Application: SSI 7485

I write regarding the proposed modification to M4-M5 Link, Mod 2 The Crescent overpass and changes to pedestrian infrastructure in North Annandale, Rozelle and Rozelle Bay Foreshore area.

Figure 4-2 Pedestrian and cyclist bridge infrastructure options

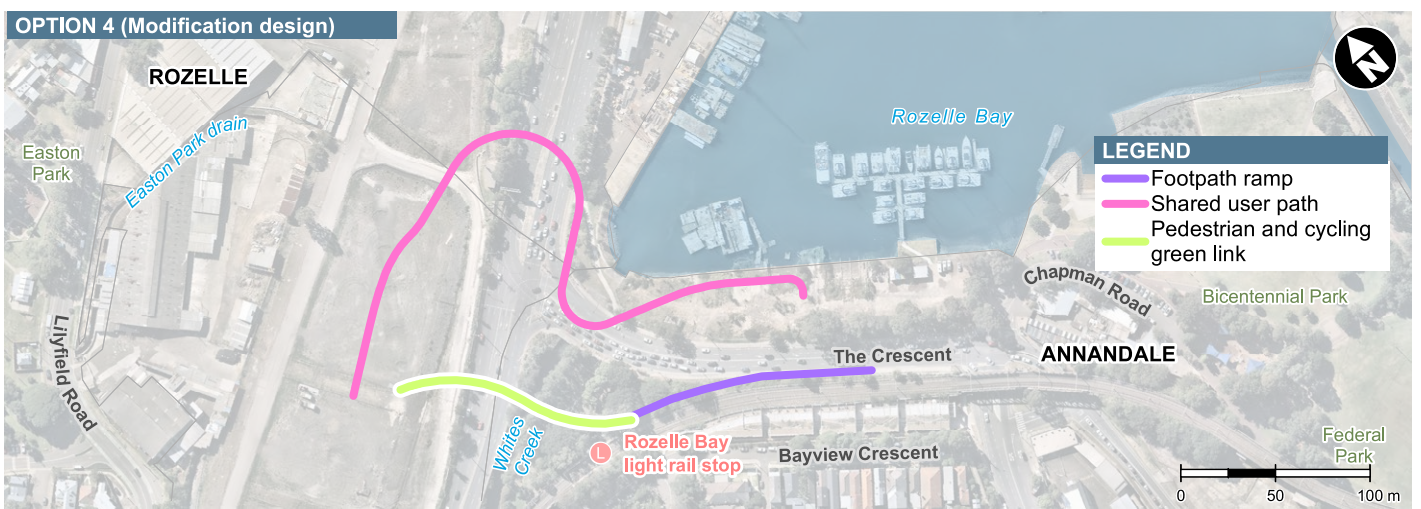
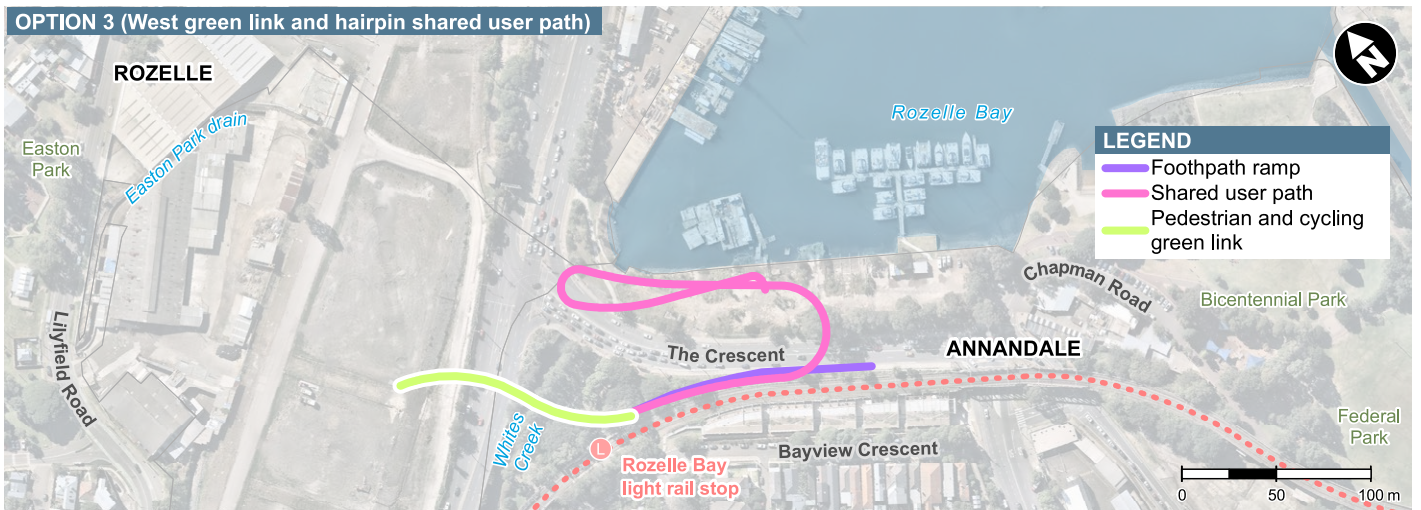
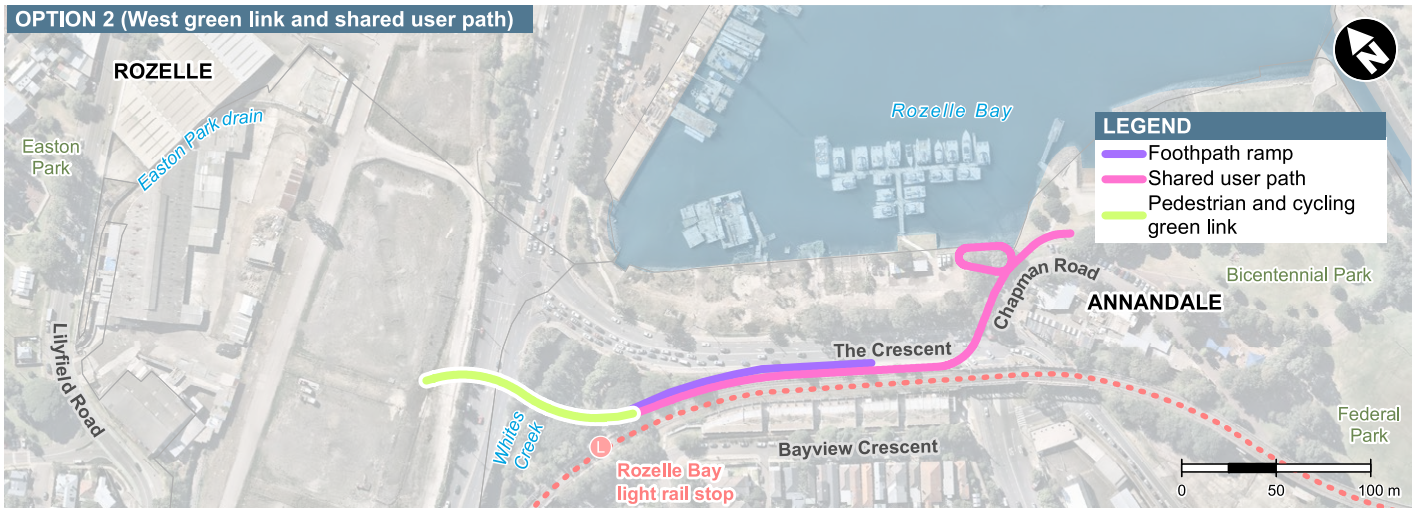
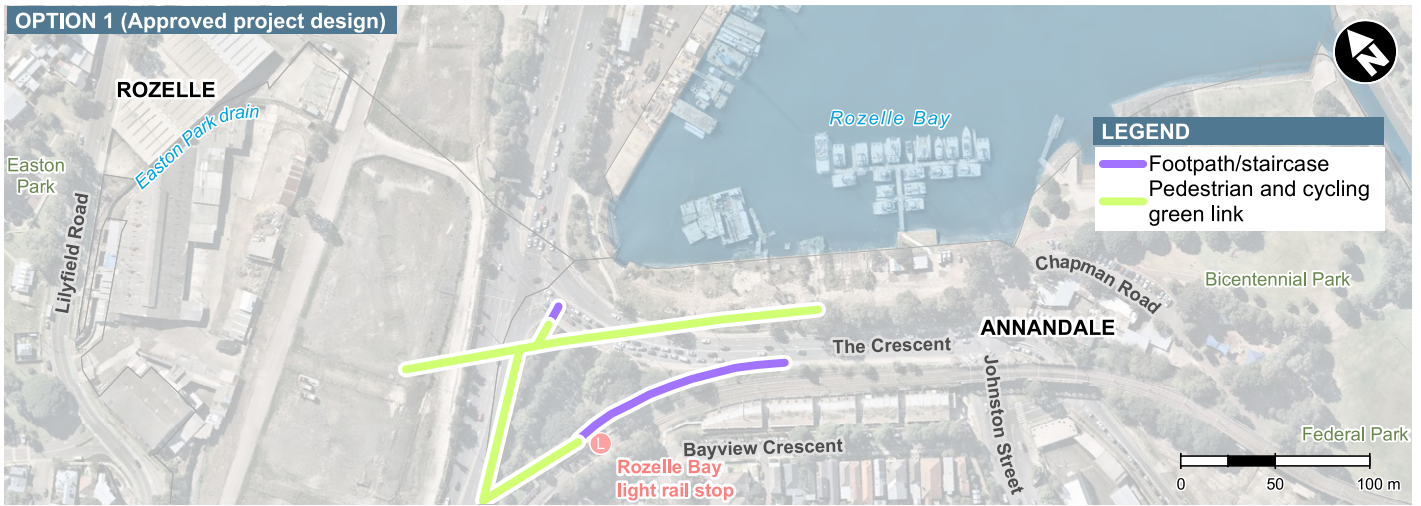
I request RMS work with the community to explore alternate design options to the proposed new car overpass design and the changed pedestrian and cyclist links. I am seeking the reinstatement of the safe, direct access from the approved EIS GreenLink to create a continuous green open space connection from the Rozelle Rail yards and Annandale to the foreshore. The GreenLink was more than just a walk way - it put people central to the design, maximising safety, and providing much needed accessible open space for the community now and into the future Bays Precinct design.

- The significantly reduced safety and increased risk for pedestrians and cyclists with removed access over The Crescent to Bicentennial Park and the increased traffic along Johnson Street.
- Being required to cross five sets of pedestrian lights at The Crescent as my option to reach the foreshore from Annandale or from Rozelle Bay light rail stop.
- Removal of direct active links to the foreshore, cutting the community off from the area and the proposed revitalisation of the entire Bays Precinct, including linking the Light Rail and Bus stops to a Ferry wharf and Metro station.
- Urban and landscape design that is being built before a finalised Masterplan for the area.
- Traffic changes that limit movements around the suburb and create further congestion in the local streets of Annandale, Forest Lodge, Glebe, Lilyfield and Rozelle with no planning to deal with these.

crossing five sets of lights at the crescent
will create significant safety issues for our
daily walk to and from our childrens'
daycare (aged 3+5). The morning are already
incredibly busy and this additional change
is concerning for us.

- Reinstate the GreenLink connecting communities and green open space from Rozelle to Bicentennial Park
- Relocate and design pedestrian and cyclist connections that are continuous, safe and direct.
- Design the modification infrastructure and active links in response to the character of the suburbs, the location of the foreshore and it's potential future development.
- Provide pedestrian and cyclist paths that maximise people safety and do not force them onto busier streets, unsafe concrete plazas and caged walkways.
- Integrate active and direct connections to all active transport – including the future Metro West and Foreshore Ferry Wharf
